Application Ref: H02-0800-26

Proposal: **Change of use of retail ground floor to residential**

Location: **8 North Street, Crowland, Spalding, PE6 0EF**

MR. M. CLOUGH	CHANGE OF USE FROM RETAIL TO RESIDENTIAL AT 8a NORTH STREET, CROWLAND	1 : 500	BLOCK PLAN
JANICE KENDRICK DESIGN SERVICES	e-mail- jkds@talk21.com tel : 07711 007209	26. 3726. 03

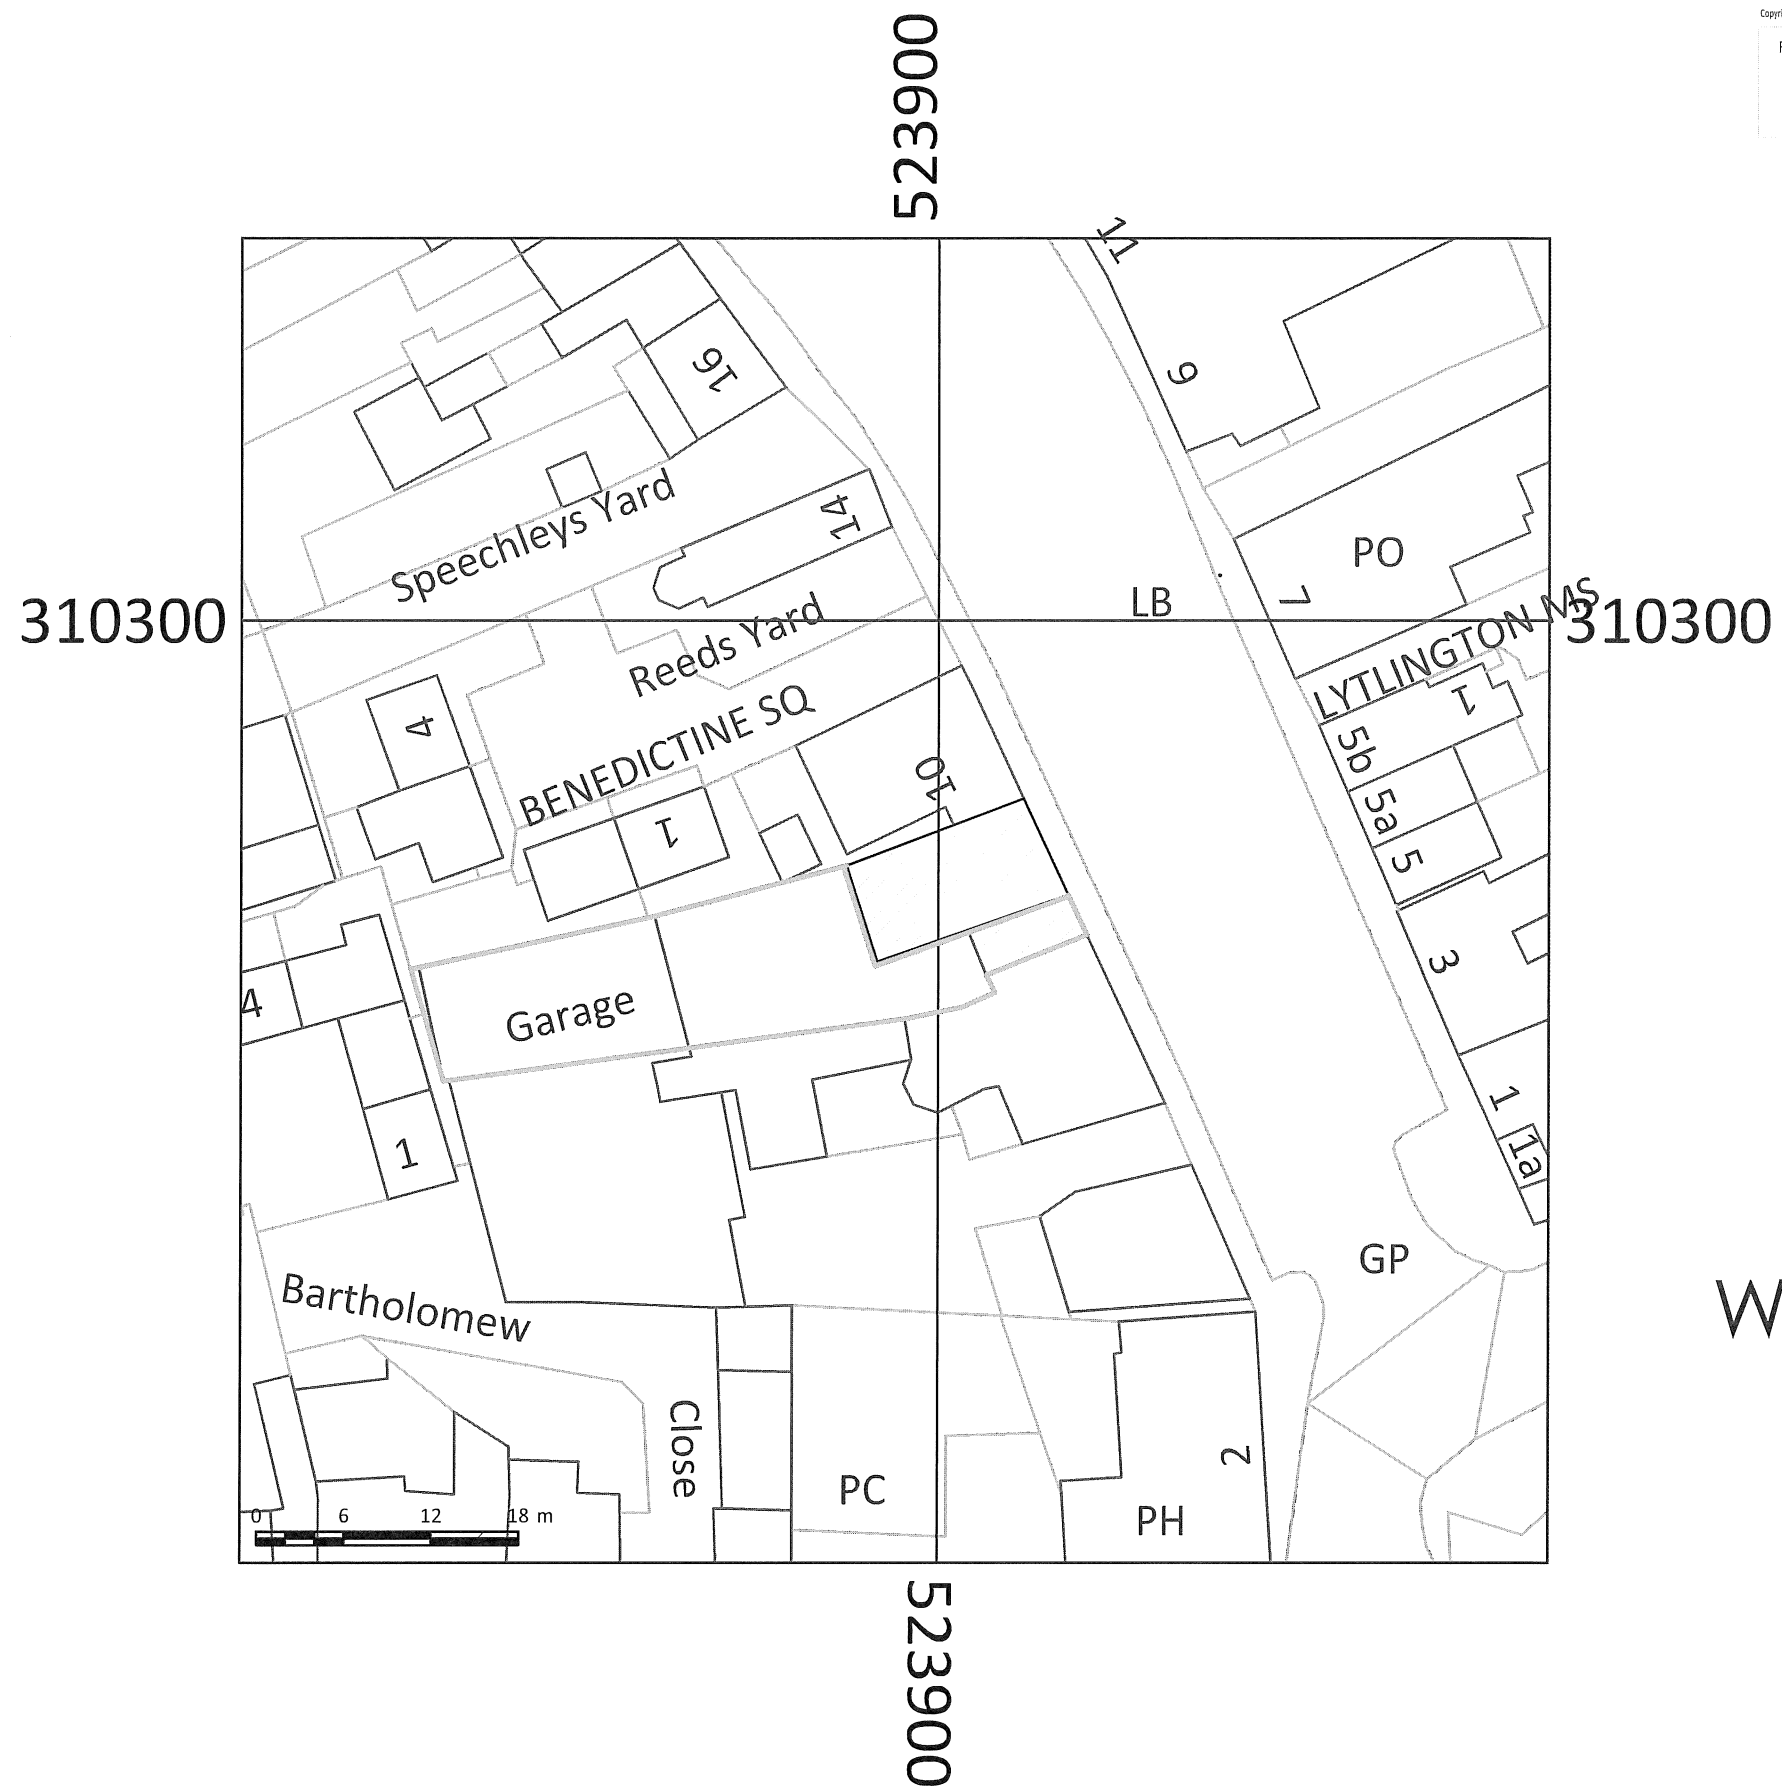
The submitted information indicates that off-street parking will be provided; however, the location of the parking space is not clearly identified on the submitted plans. A revised site plan should therefore be provided showing the parking provision and associated access arrangements.
